SLR Ref No.: 610.30495-L02-v2.0-20260629.docx

Client Reference: 45-53 Macleay Street

**RE: 45-53 Macleay Street, Potts Point
Council and Urbis Comments Addressed**

Figure 1 Bulky waste storage areas

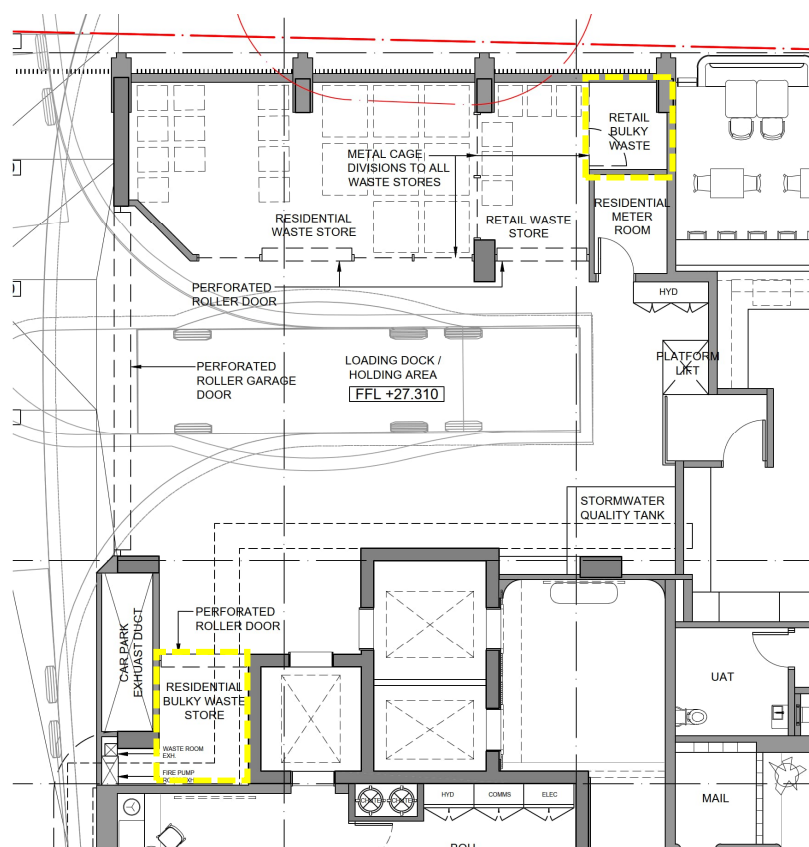
The bulky waste and problem waste storage area must be designed in accordance with Section B.2.2 of the Guidelines

Section B.2.2 requires a lockable cage, designated screened area or room in or attached to the storage area dedicated for bulky waste and problem waste.

New drawings have been prepared that show retail and residential bulky waste areas that comply with these requirements. These are shown in Figure 1 below.

Figure 2 Retail and residential waste storage areas

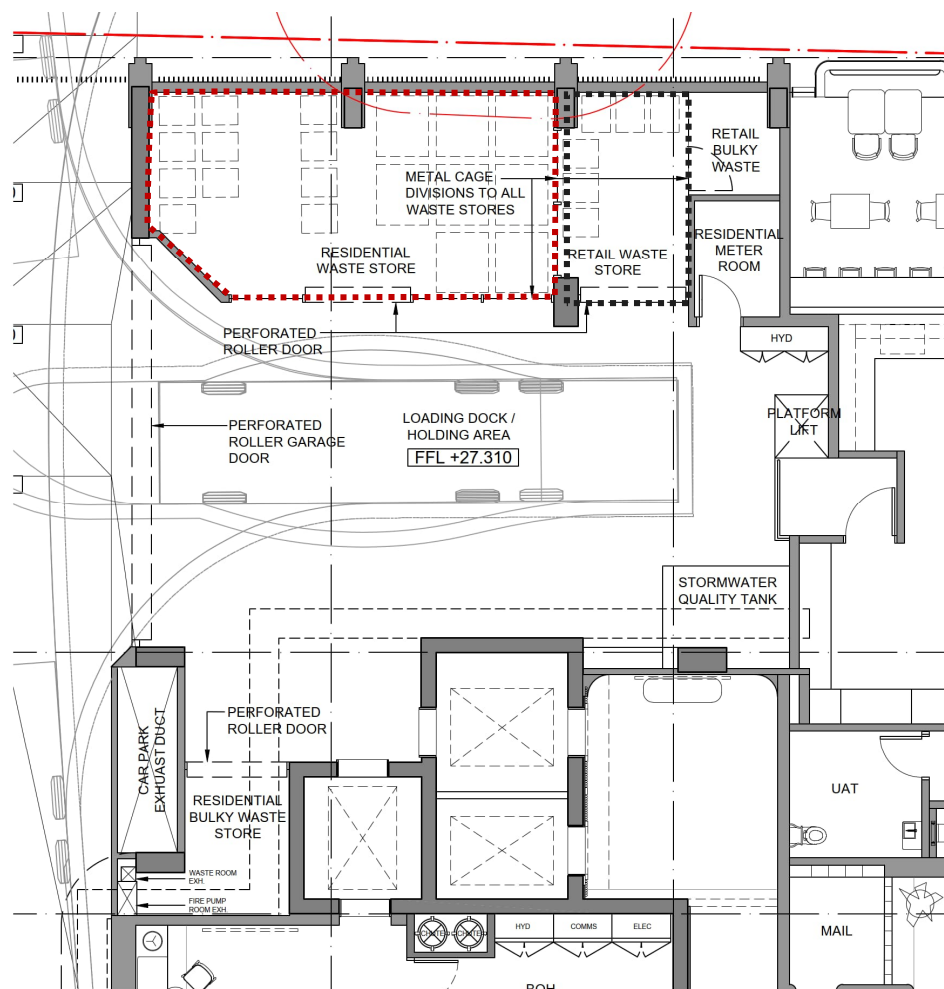
The proposed development must ensure that waste and recycling systems for the residential (residential) and non-residential (Commercial/Retail) components are entirely separate and self-contained in accordance with Section E.1.1 of the Guidelines

The design of the development has been amended to allow for separate and secured residential and retail waste storage areas. These are shown in Figure 2 below.

Figure 3 Retail access to loading dock

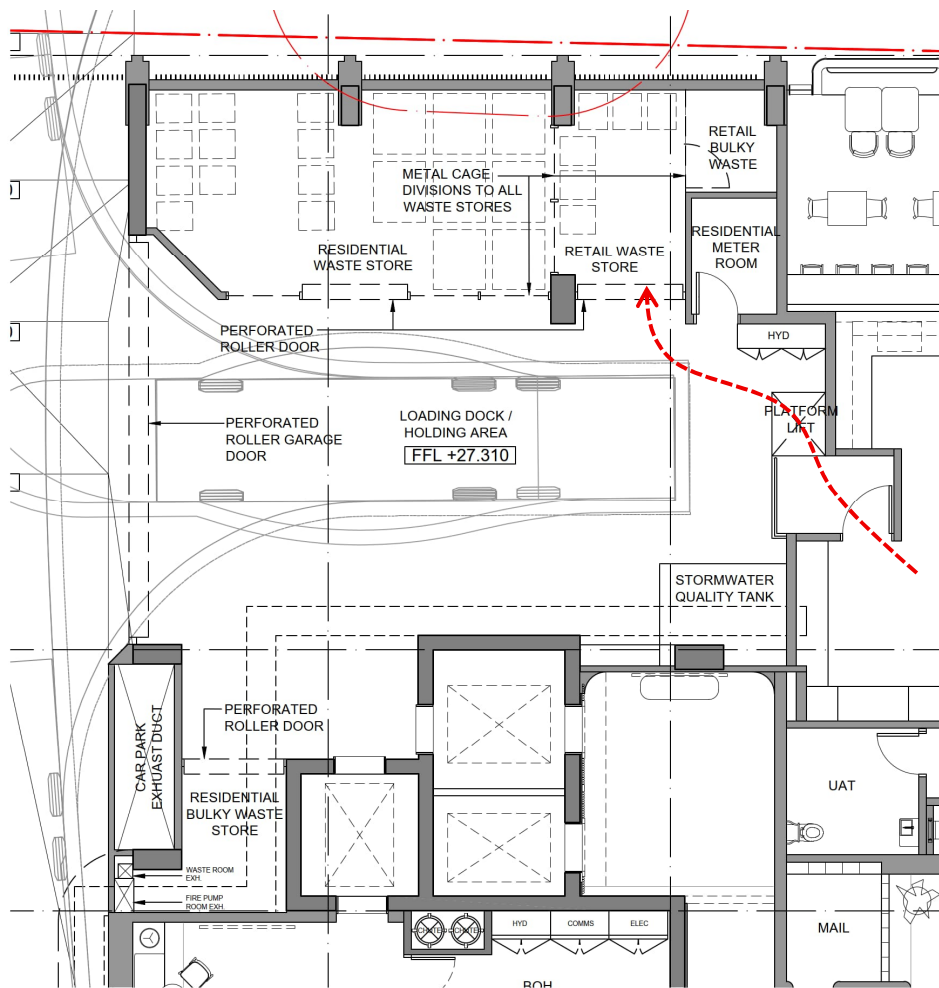
All waste transfer must be completed wholly within the development, without relying on the public domain

The design of the development has been amended to allow access to the loading dock from within the retail tenancy. No waste transfer across public areas is proposed. This is shown in Figure 3 below.

Figure 4 Dual chutes

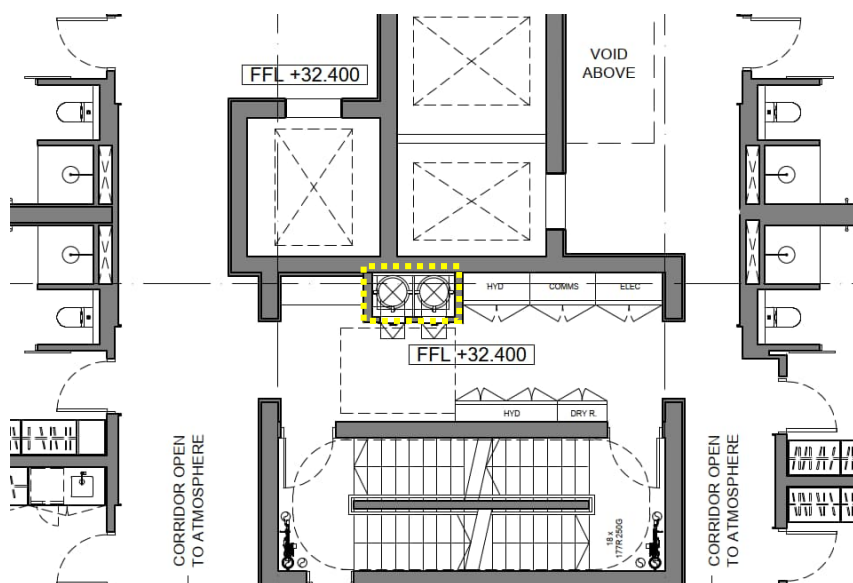
The use of a single e-diverter chute system for the residential component is not supported as it has a high contamination rate. A dual-chute system must be provided to facilitate intuitive source separation.

The design of the development has been amended to allow for two chutes to be installed, one for garbage and one for recyclables. This is shown in Figure 4 below.

Figure 5 Chute room

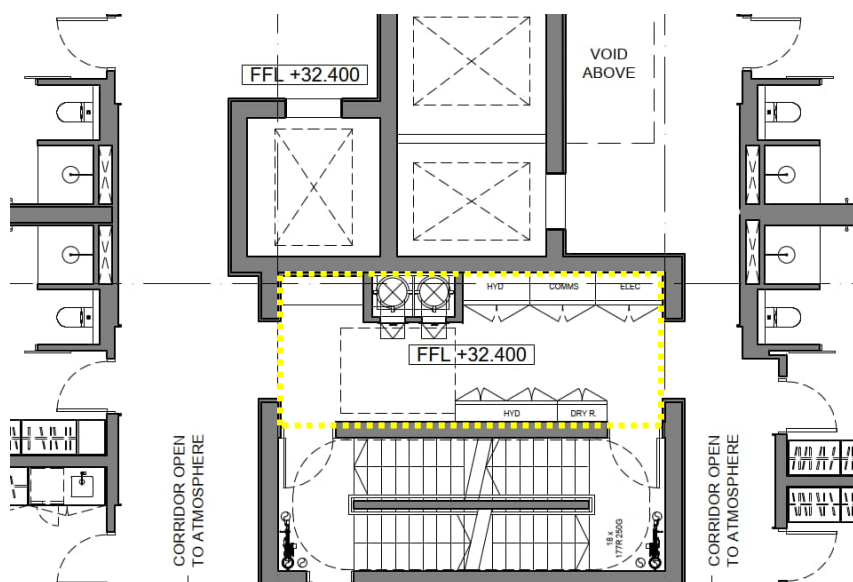
FOGO disposal points should be provided on every residential level as per Section B.4.1 as the current proposal requires residents to carry food waste to a centralised location in the basement, which exceeds the maximum allowable travel distance of 30 m from the unit entrances.

Section B 4.1 says that *A chute room is required on each habitable floor of a development that has a chute system.* The development already complies with this requirement as shown in Figure 5 below

Despite that, and with regard to the NSW Government Food Waste Mandate, a FOGO room has been provided on a basement level, and a FOGO disposal point will be provided on Levels 1 and 2. These will be serviced and managed by the building manager or affordable housing provider. The distance from the furthest residential door to the FOGO disposal point is 19 m which is well within the 30 m requirement.
